Application for a non-material amendment following a grant of planning permission.

| <input type="text" value="Demolition of dwelling: proposed replacement dwelling."/> | |
| Reference number: | <input type="text" value="P/00265/19"/> |

Change of cladding from black timber boarding to vertical slate hanging.
Reduced windows and size on south and north elevations.

South elevation.  
Proposed amendments.

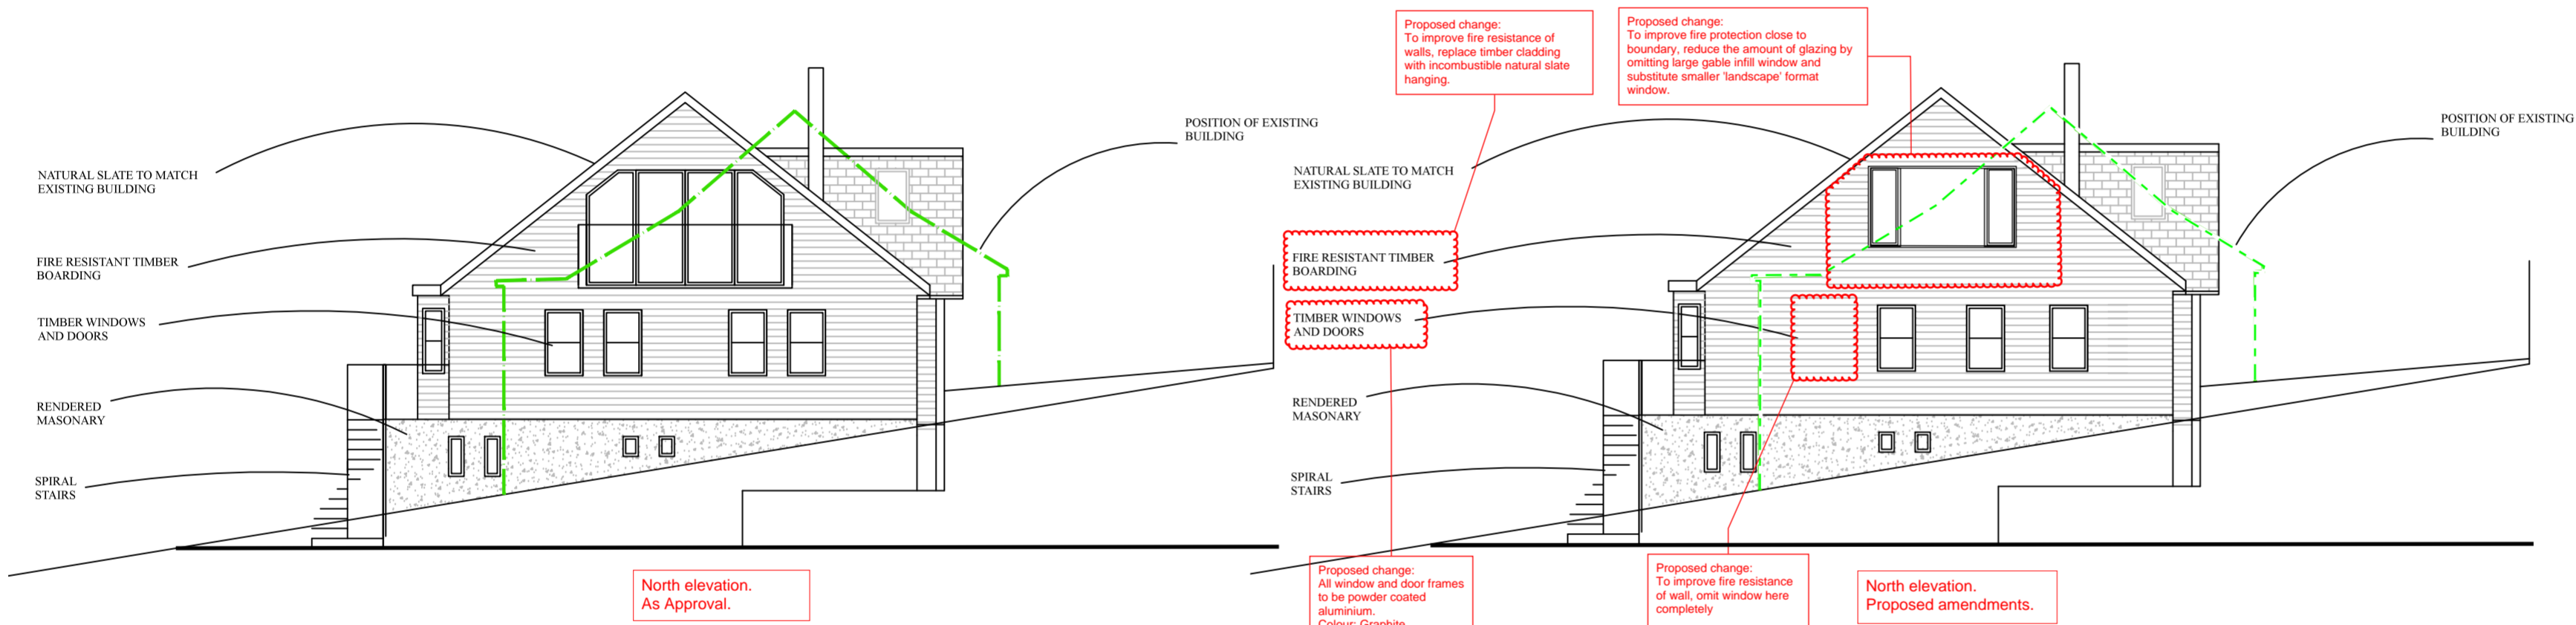
South elevation. The reduction in glazing area and number of windows improves the fire protection and privacy on the this boundary.
Obscured glass will be used as Condition 3 of the original Consent.

North elevation.  
Proposed amendments.

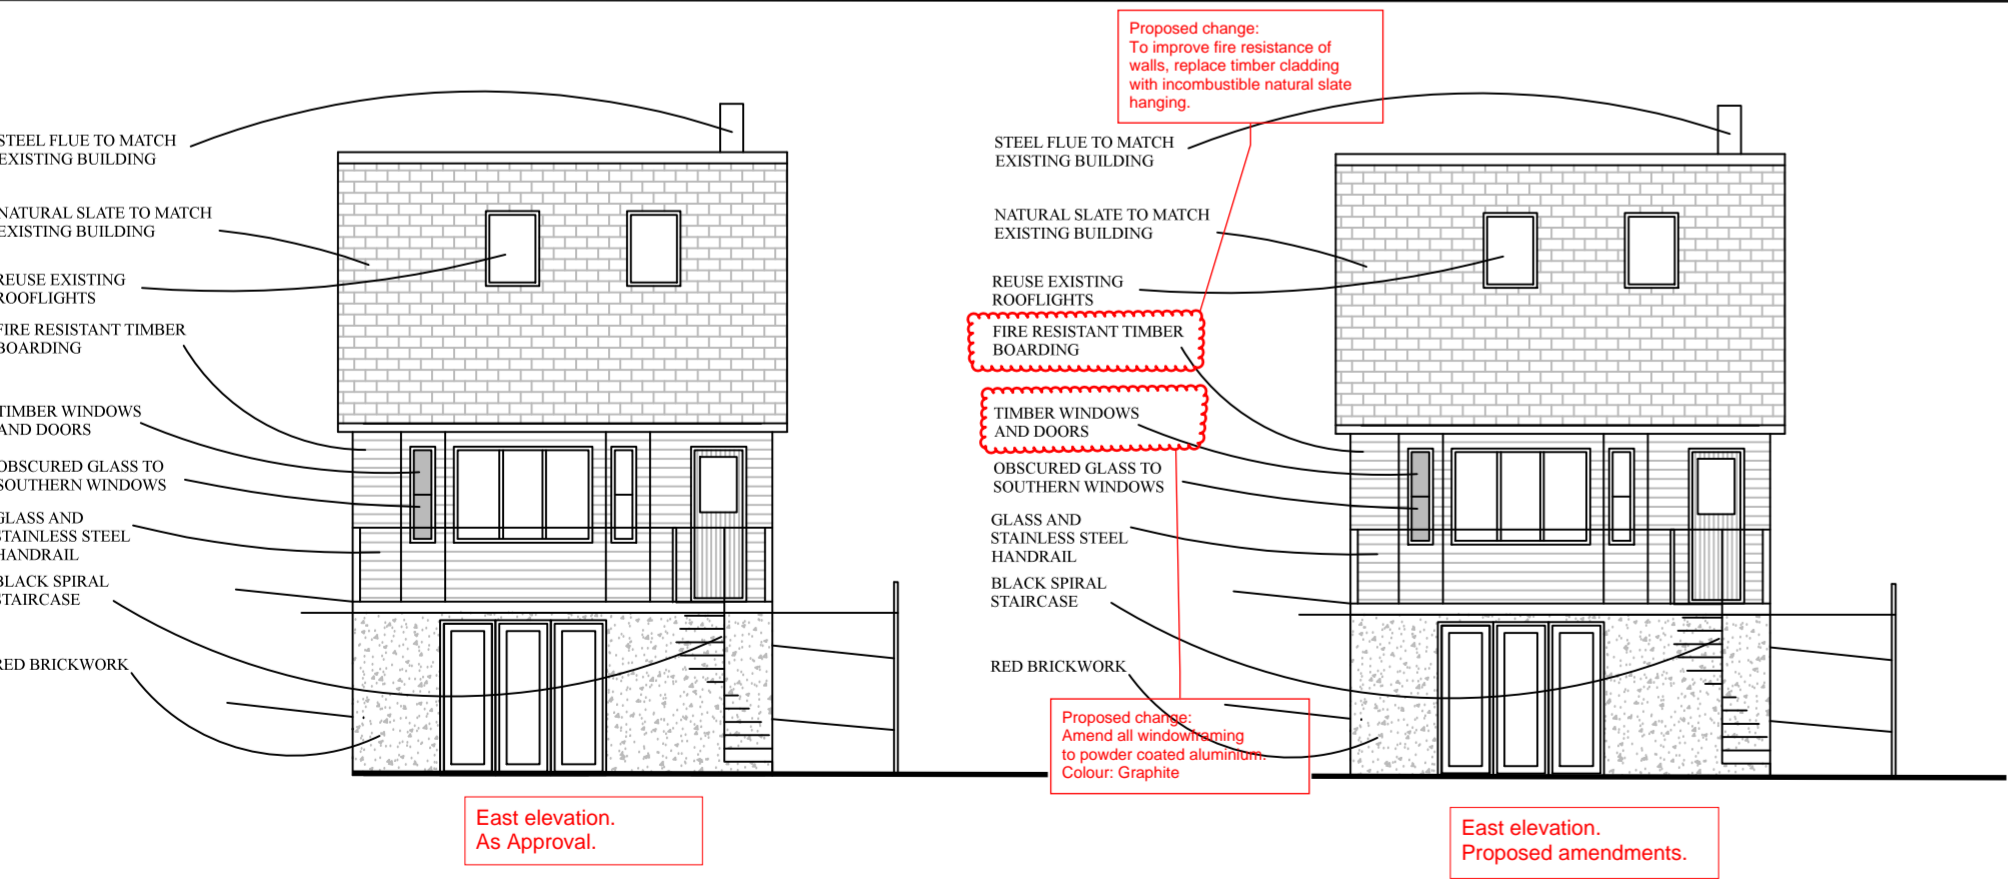
North elevation. The reduction in glazing area and number of windows improves the fire protection on the this boundary.
